SUBJECT: Preliminary Review of Proposed Subdivision Plan for the David Elliott  
Property, Great Diamond Island.

FINAL REVIEW OF GREAT DIAMOND SHORES SUBDIVISION,  
PHASE I, ON GREAT DIAMOND ISLAND - DAVID L. ELLIOTT

TO: Warren S. Turner, Planning Department  
FROM: John P. Rague, Department of Public Works  
SUBJECT: Review of Final Plat for Gt. Diamond Shores Subdivision

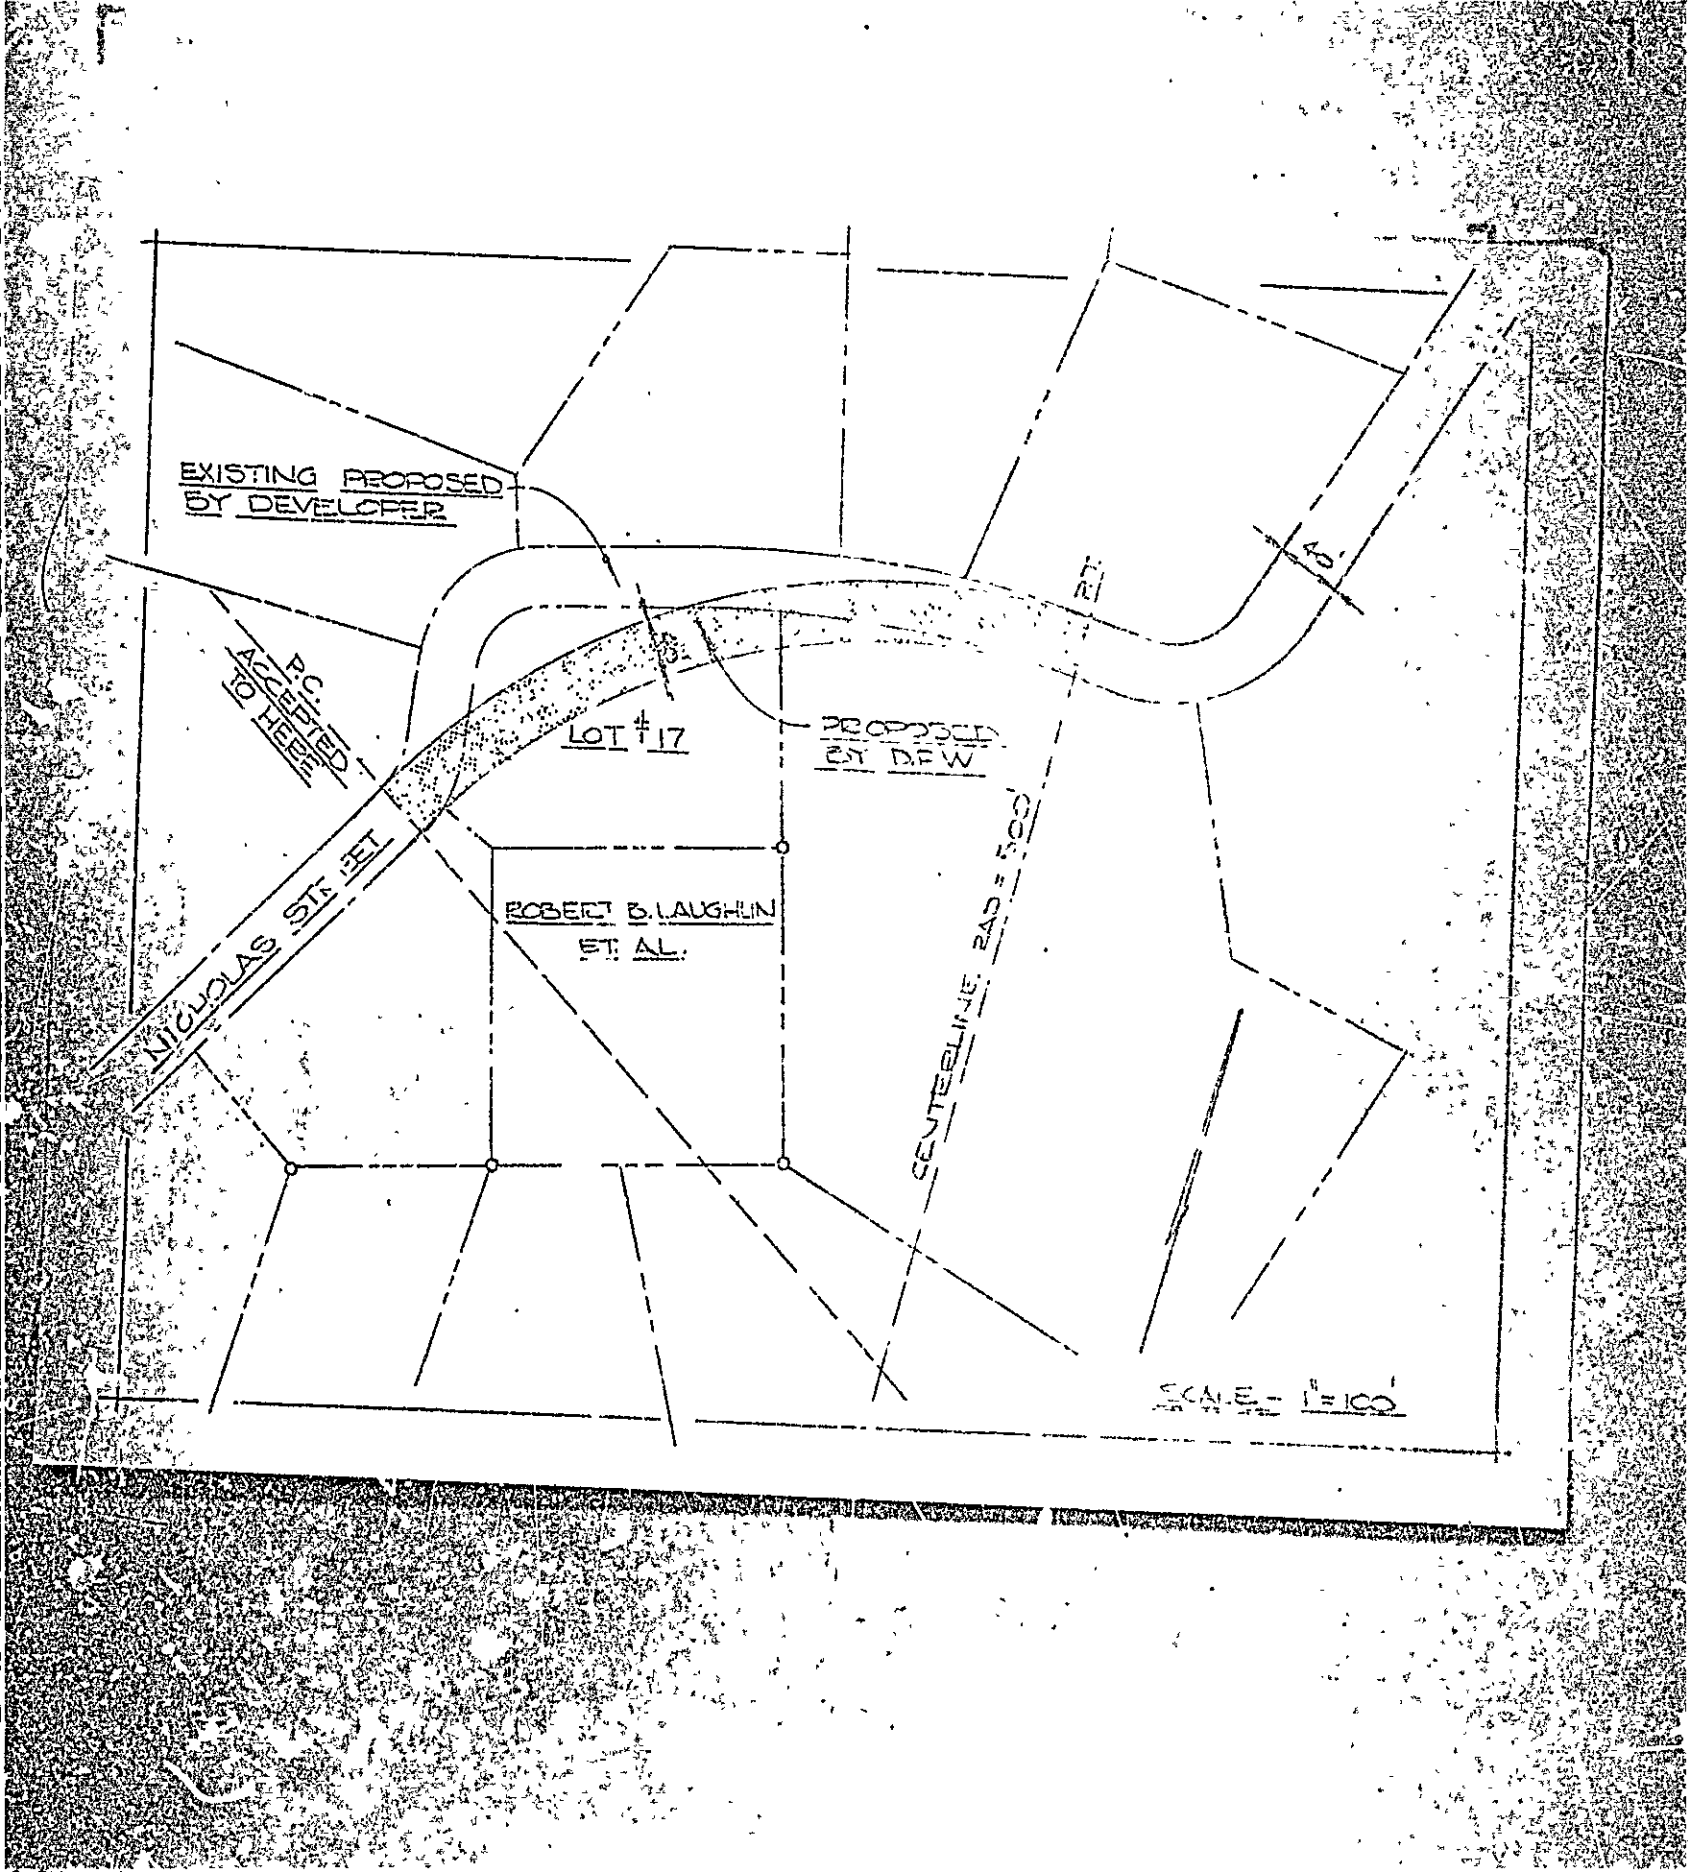
J.W. Alignment of the Proposed Sunset Avenue Extension:

Proposed alignment of Sunset Avenue Extension appears to be prohibitive to proper vehicular turning movements. Department would recommend that such proposed alignment be changed as shown on the attached sketch.
